TRANSPORT FOR LONDON

M25 JUNCTION 28 IMPROVEMENTS – DEADLINE 5 SUBMISSION

13 APRIL 2021

Client		Project		GROVE FARM ACCESS, JUNCTION 28 M25 NORTHBOUND SLIP LANE	
MR L JONES & MRS K JONES		Title		ACCESS ALTERATIONS TO GROVE FARM	
Status	Drawn	Scale	Sheet Size	Date	Drawing No.
FOR APPROVAL	PL	1:1000	A3	JAN 2021	REDW-3396-110
				Rev

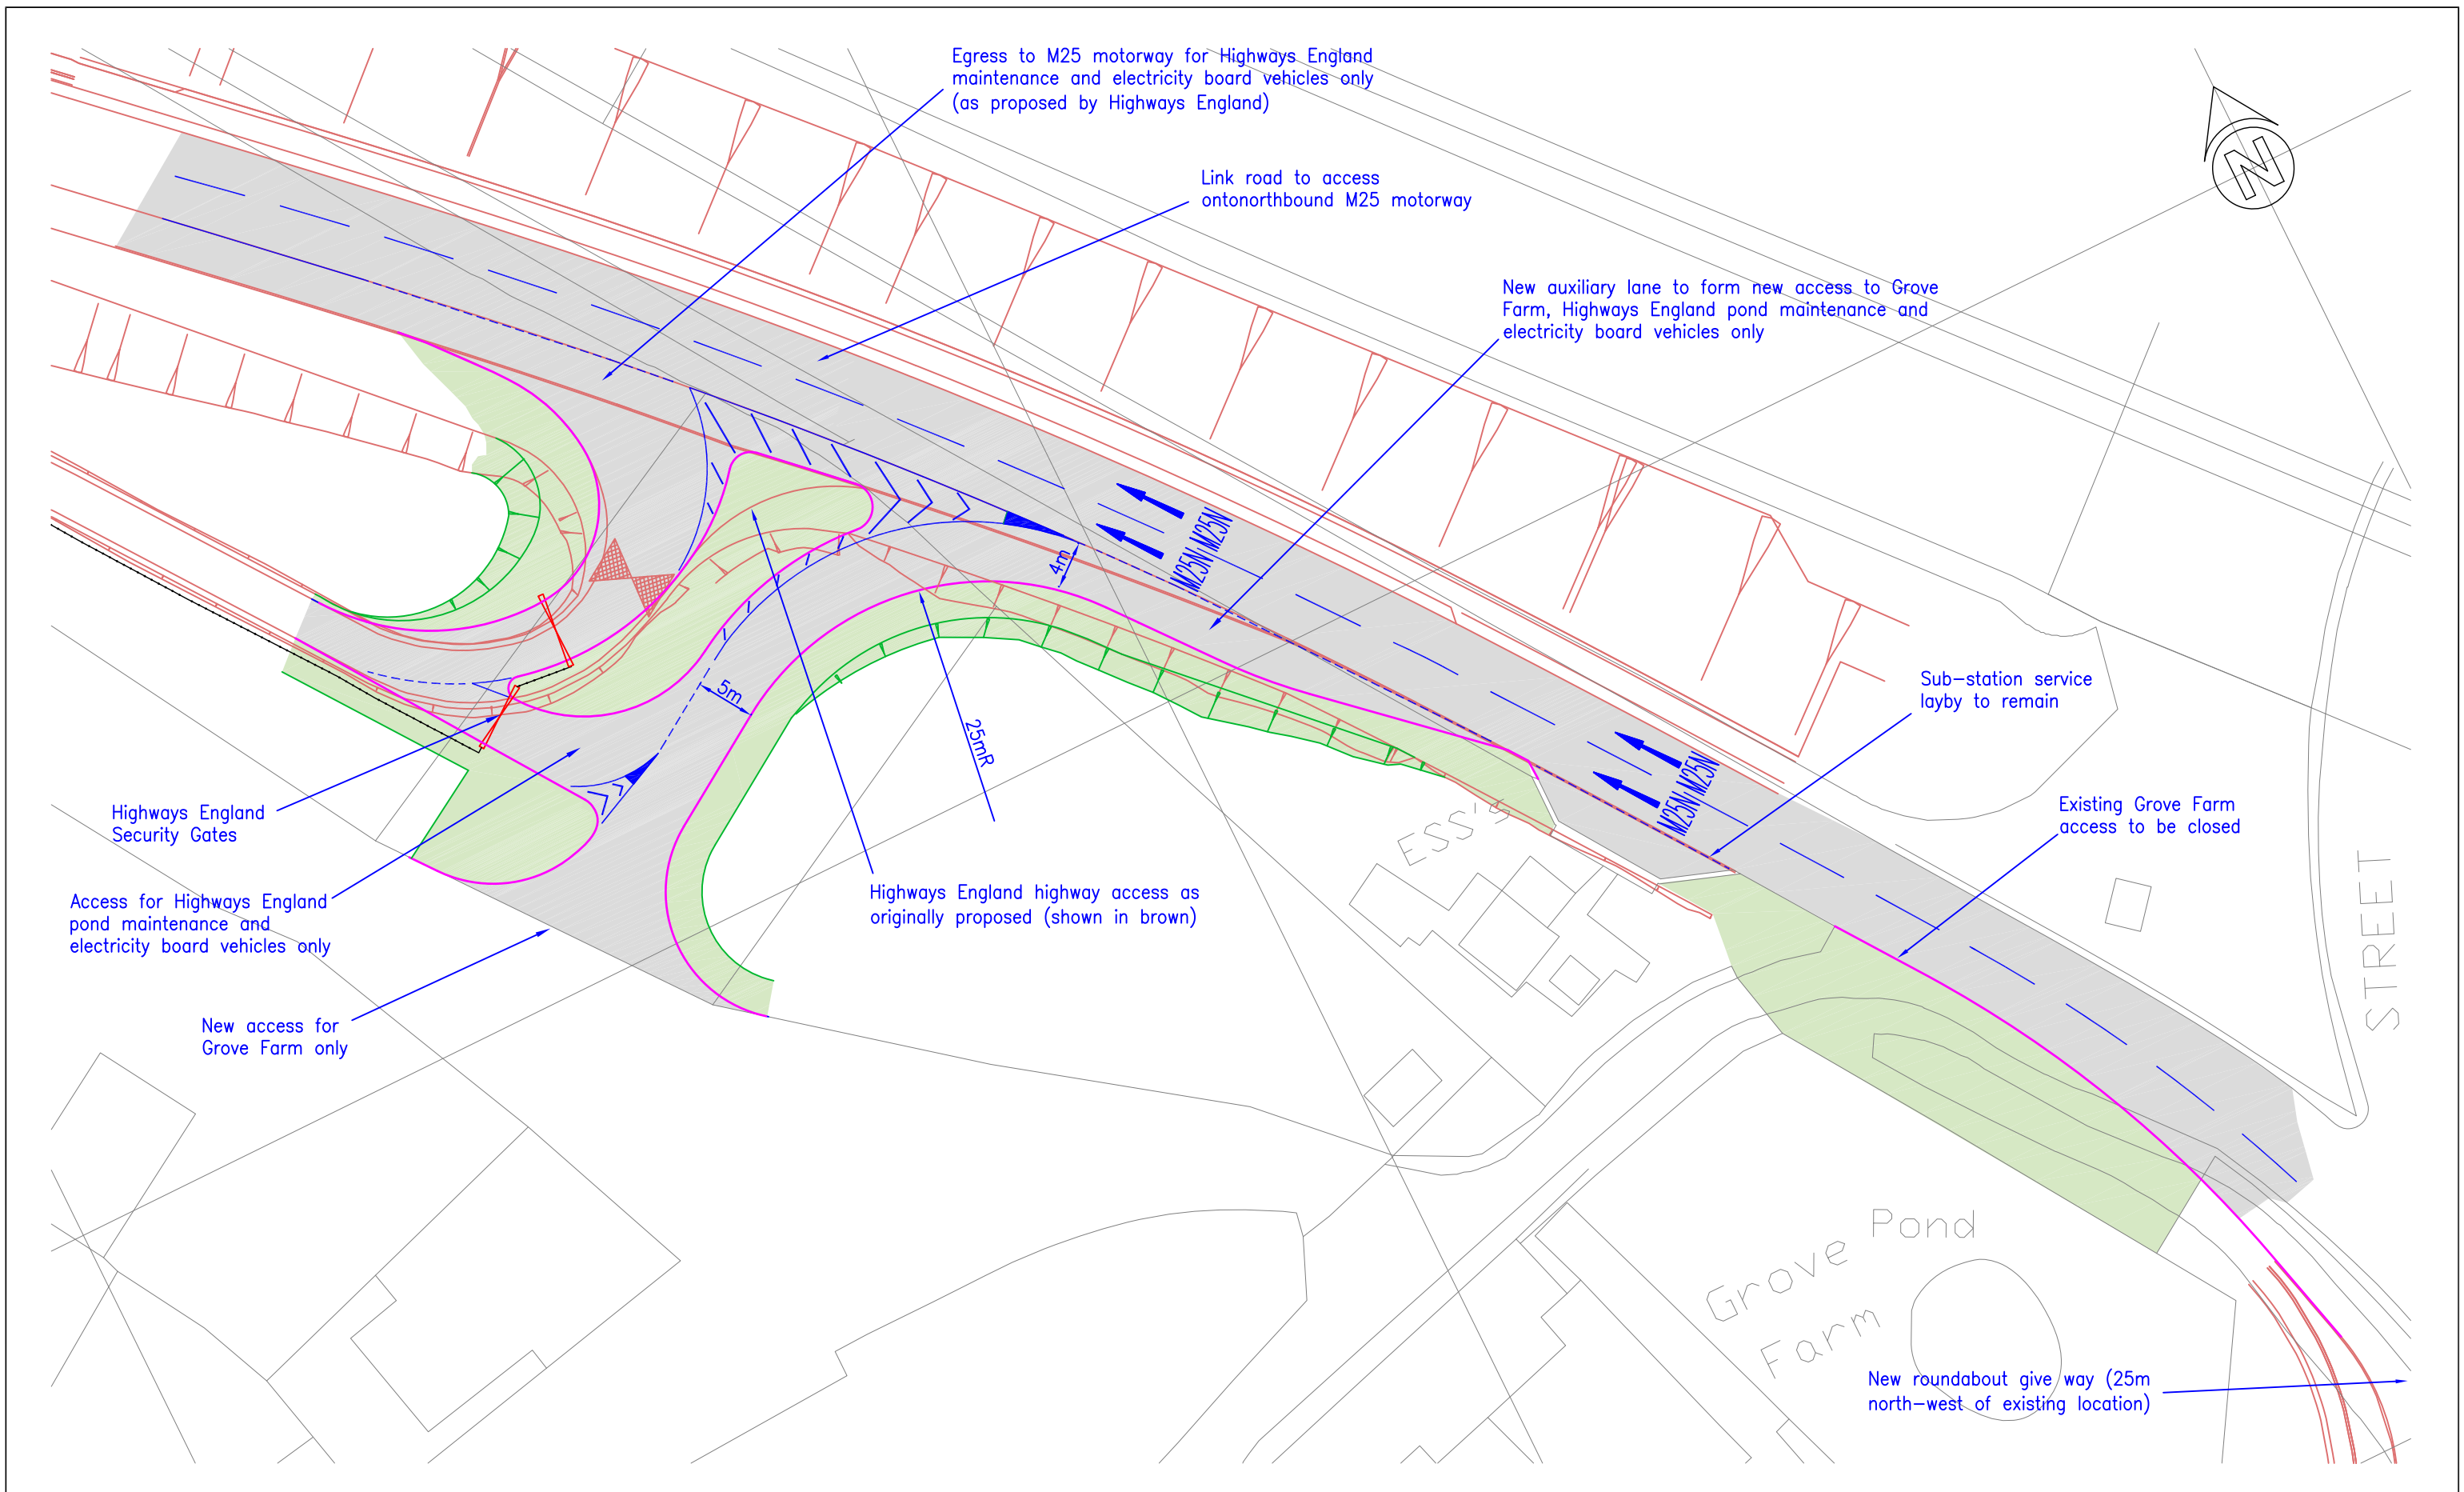
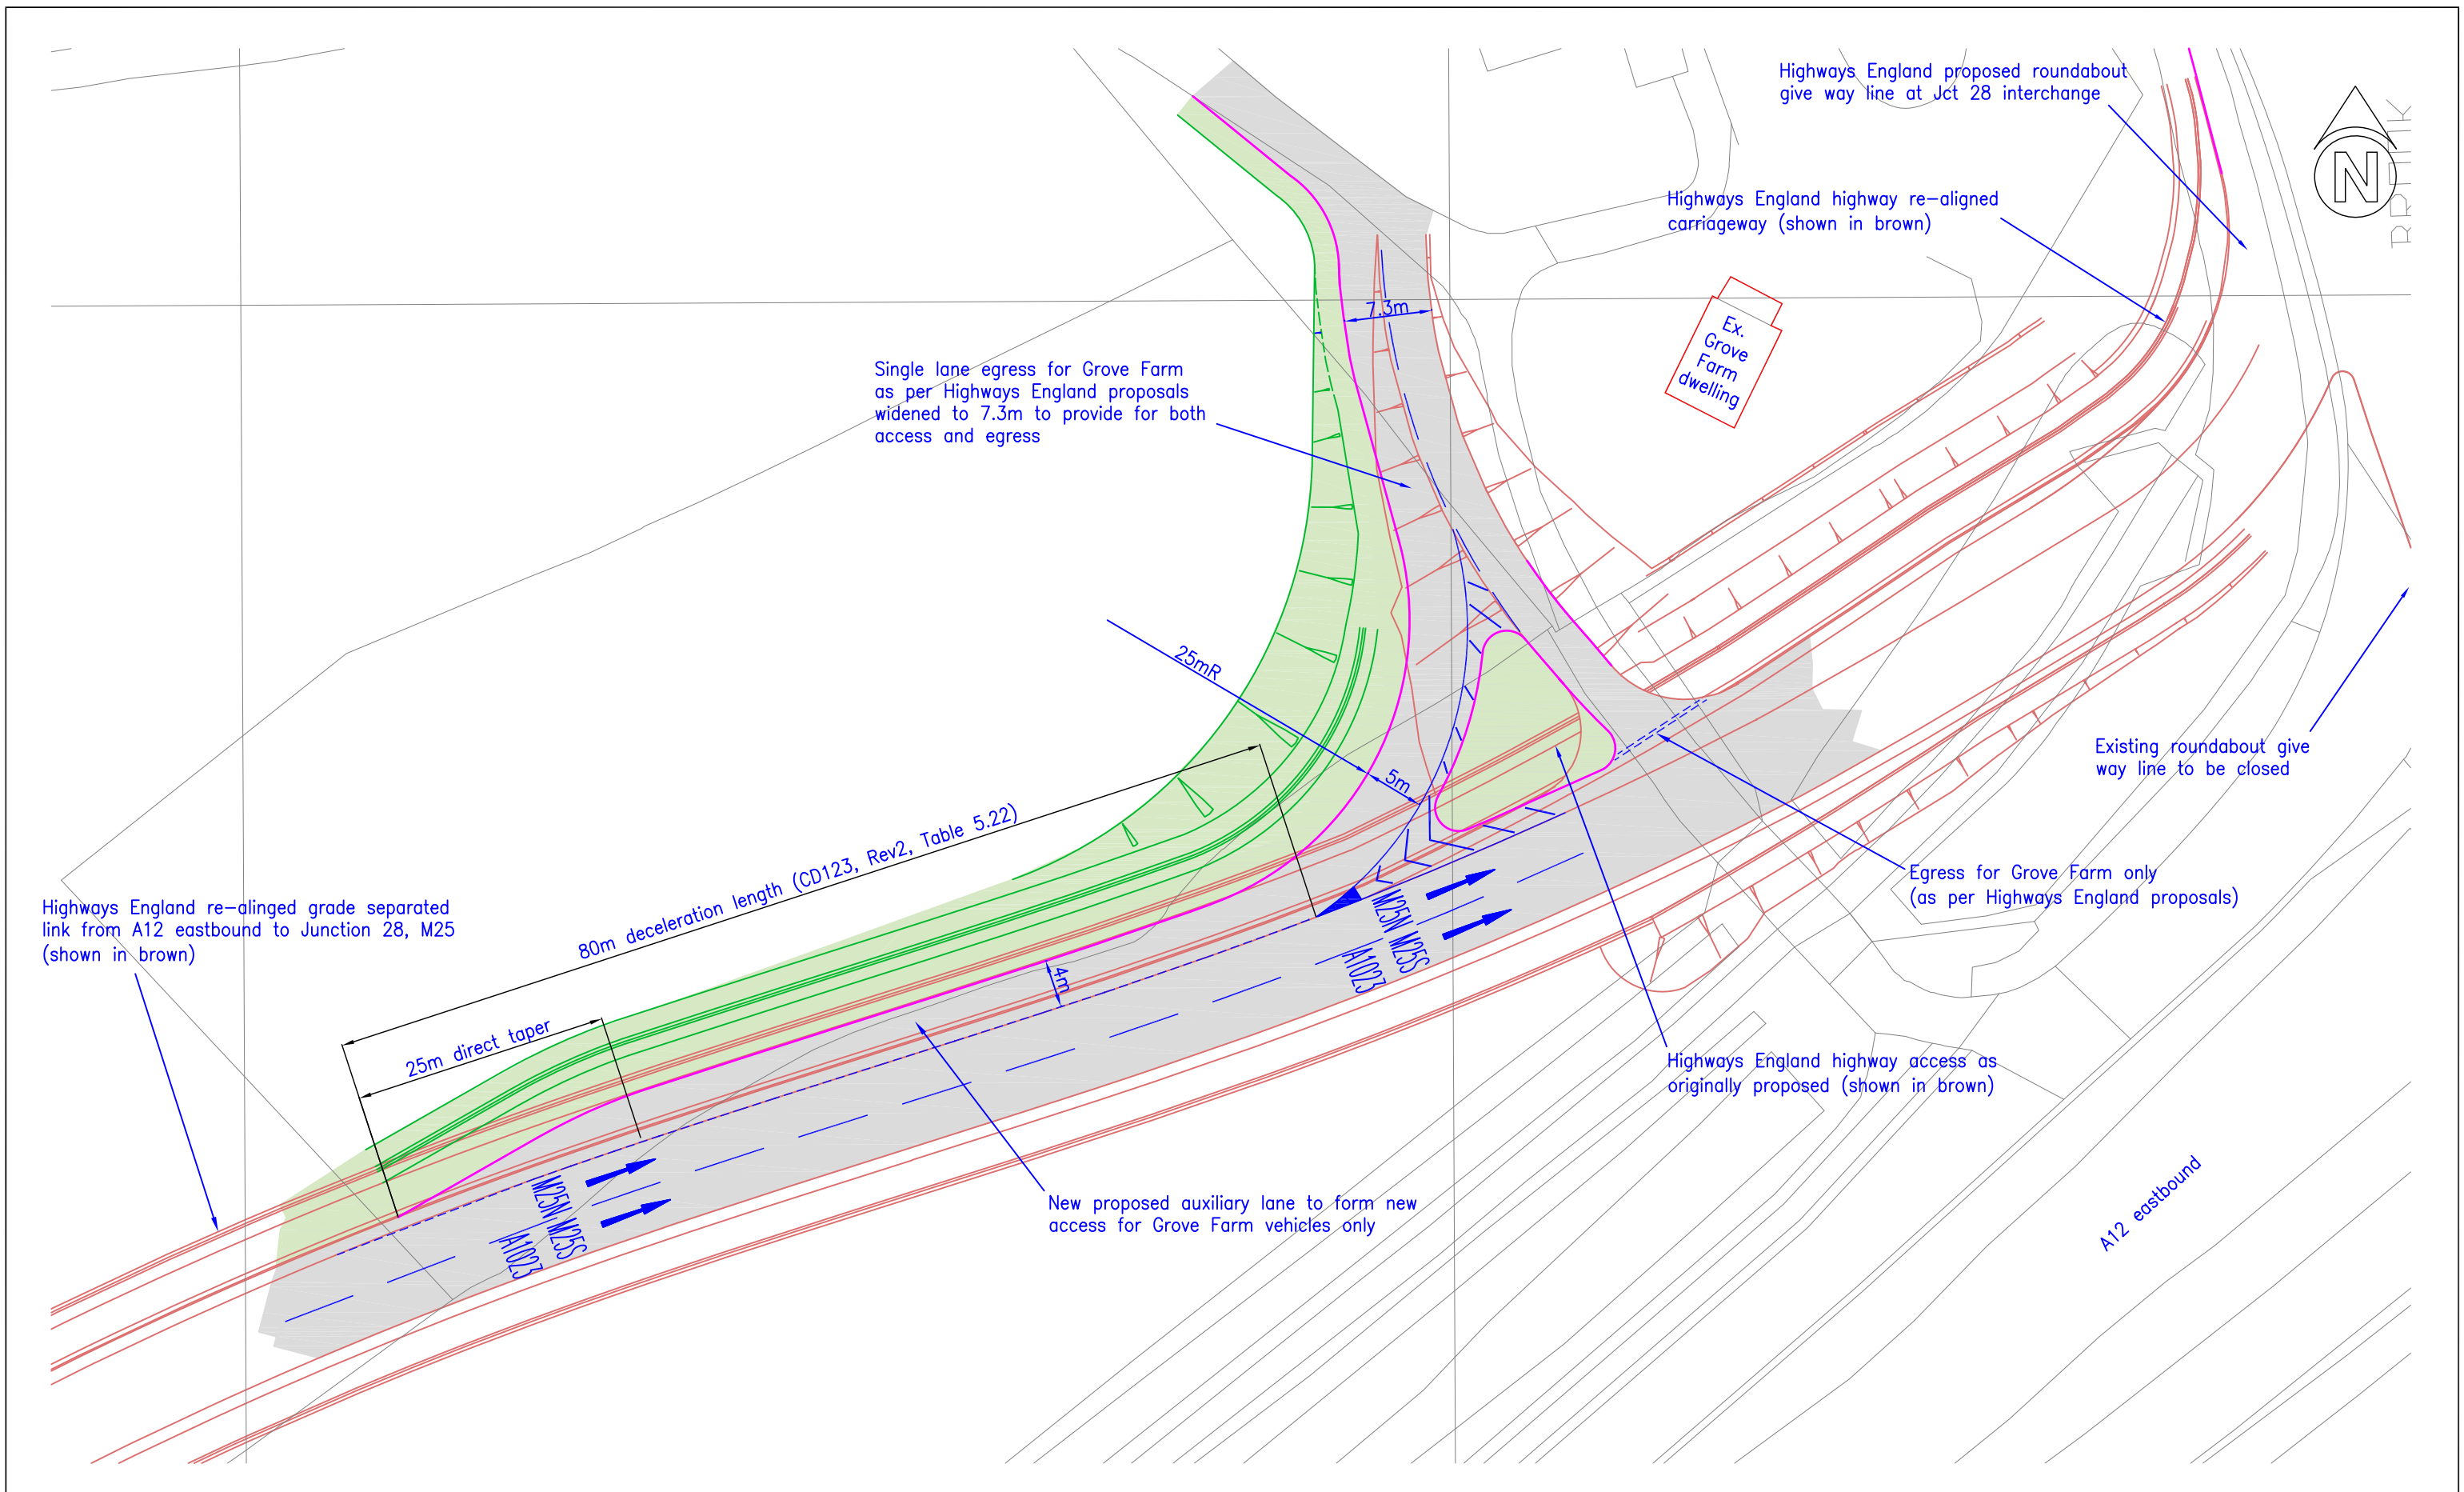
TA 2.3	<p><i>Proposed Access / Egress at Grove Farm</i></p> <p>The Applicant Transport for London London Borough of Havering</p>	<p>The representatives of Mr & Mrs Jones submitted revised proposals at Deadline 4 [REP4-036] for access / egress to and from their property.</p> <p>Provide comments on these proposals.</p>	<p>TfL has reviewed the proposed new location for the egress from Grove Farm onto the new A12 eastbound off slip road set out in the plan in document REP4-036. This results in the egress being located approximately 120 metres from the proposed stop line at the roundabout instead of the current distance of approximately 70 metres, an increase of 50 metres.</p> <p>TfL has not identified any immediate safety concerns with this proposal when compared with the layout currently proposed by the Applicant. It would be important to demonstrate that there is sufficient visibility to and from the new egress location for the required design speed. The alternative egress location may require a new or revised departure from standards.</p>

TfL is not able to comment on the proposal in terms of construction feasibility or environmental impacts and we would expect the Applicant to consider these alongside a full assessment of road safety implications.
TA 2.4	<i>Outline Traffic Management Plan</i> The Applicant Interested Parties	An outline TMP was submitted by the Applicant at Deadline 4 [REP4-013]. The ExA notes that the outline TMP does not appear to address the impact of temporary closures to the A12 eastbound off slip to junction 28 and any associated diversions during construction work. <u>For the Applicant:</u> i) Confirm that temporary closures are no longer considered necessary for this section of road. If this is not the case indicate where the diversion caused by such a closure is described in the outline TMP. <u>For Interested Parties:</u> ii) Comment on the outline TMP.	TfL's response to this question is set out in Section 4 of this document.
